# SPR EA1N and EA2 PROJECTS

## DEADLINE 8 – POST HEARING SUBMISSIONS (ISH13) TRAFFIC & TRANSPORT

**Interested Party:** SASES

**Date:** 25 March 2021

TITLE
A1094/ B1069 WIDENING FOR ABNORMAL INDIVISIBLE LOAD

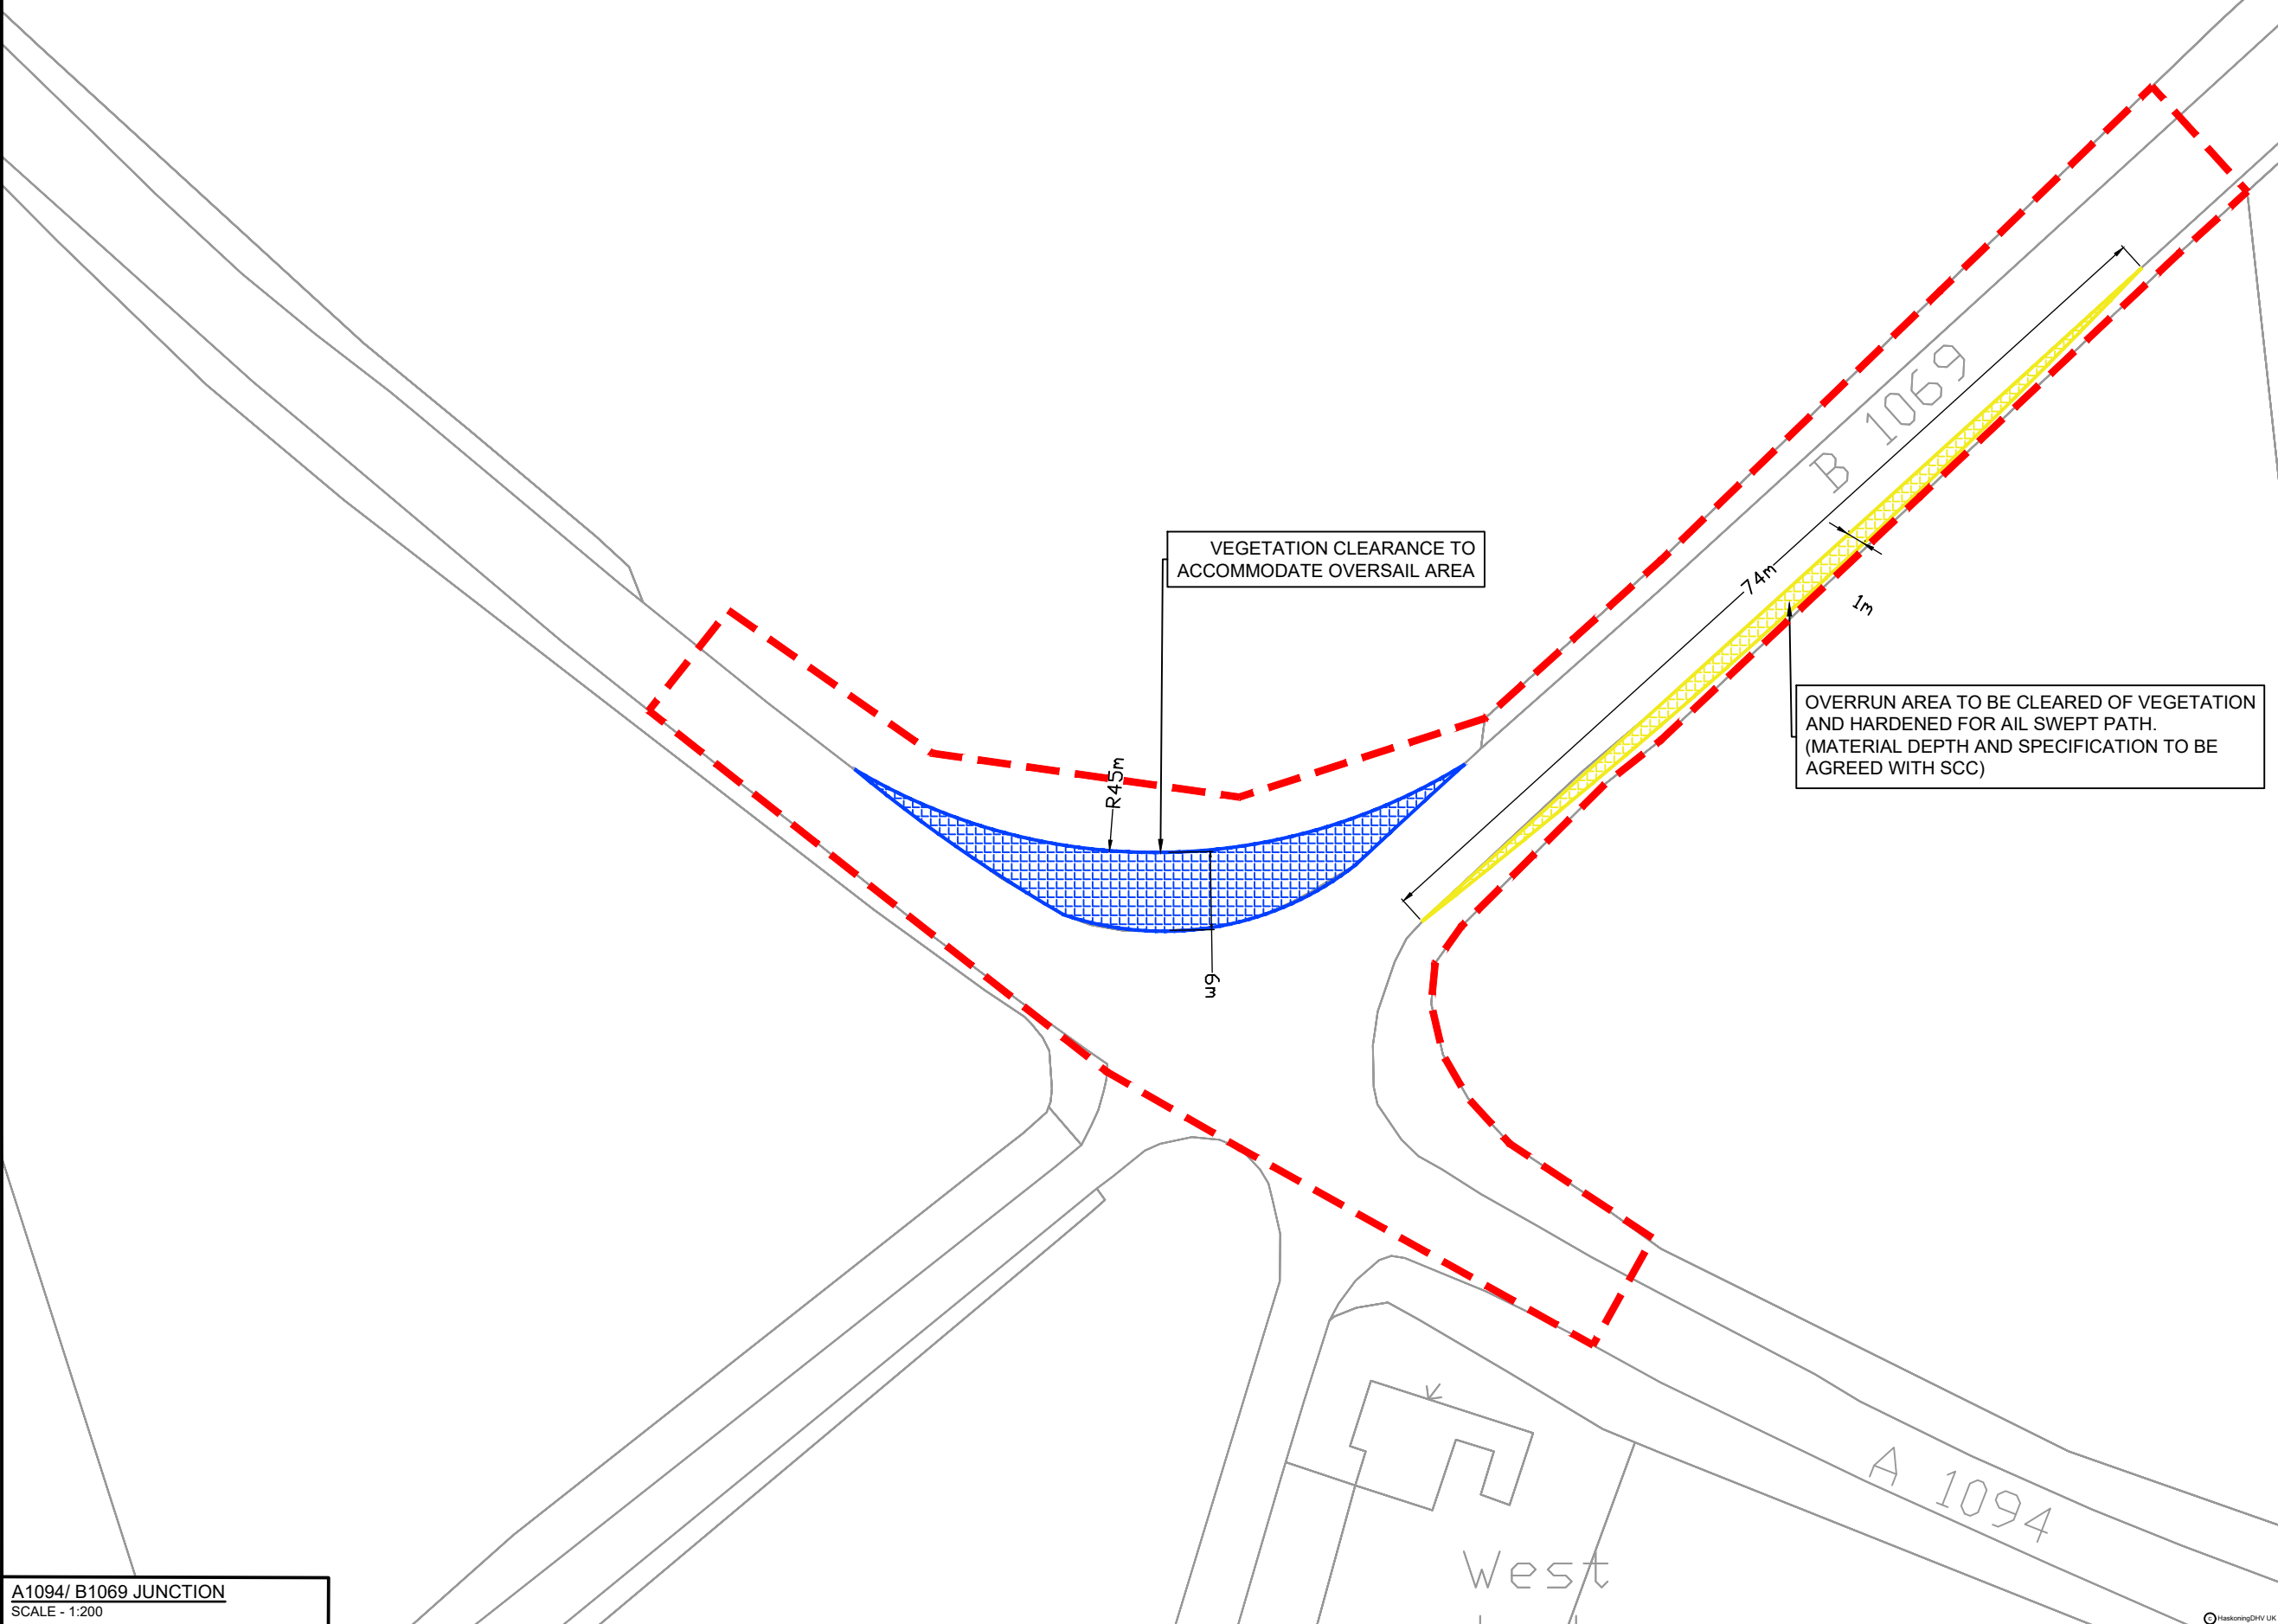
1. Steve Merry on behalf of Suffolk County Council expressed serious reservations about the Applicants' proposals referring to them as the "least worst option" and expressing concerns about the resilience of the plans. This of course derives from the Applicants' inadequate site selection when in the RAG assessment they gave Friston a green rating in respect of accessibility<sup>1</sup>. That has proved to be somewhat optimistic. The contrast with the existing Bramford substation site (indicated with the red pointer) could not be more stark as can be seen from the map below. Bramford is accessed from the A14, the major trunk road which links the container port of Felixstowe to the national motorway network. Traffic travelling from Felixstowe merely has to exit the slip road to join the B1113, the first part of which is dual carriageway. It then needs to proceed for a short distance until it turns right onto Bullen Lane which is the access road to the substation. No railway lines have to be crossed and only a single watercourse. Further the traffic does not need to pass through any towns or villages. As Councillor Fellowes of Aldeburgh Town Council noted, the delivery of AILs to this manifestly easily accessible location still caused serious problems.
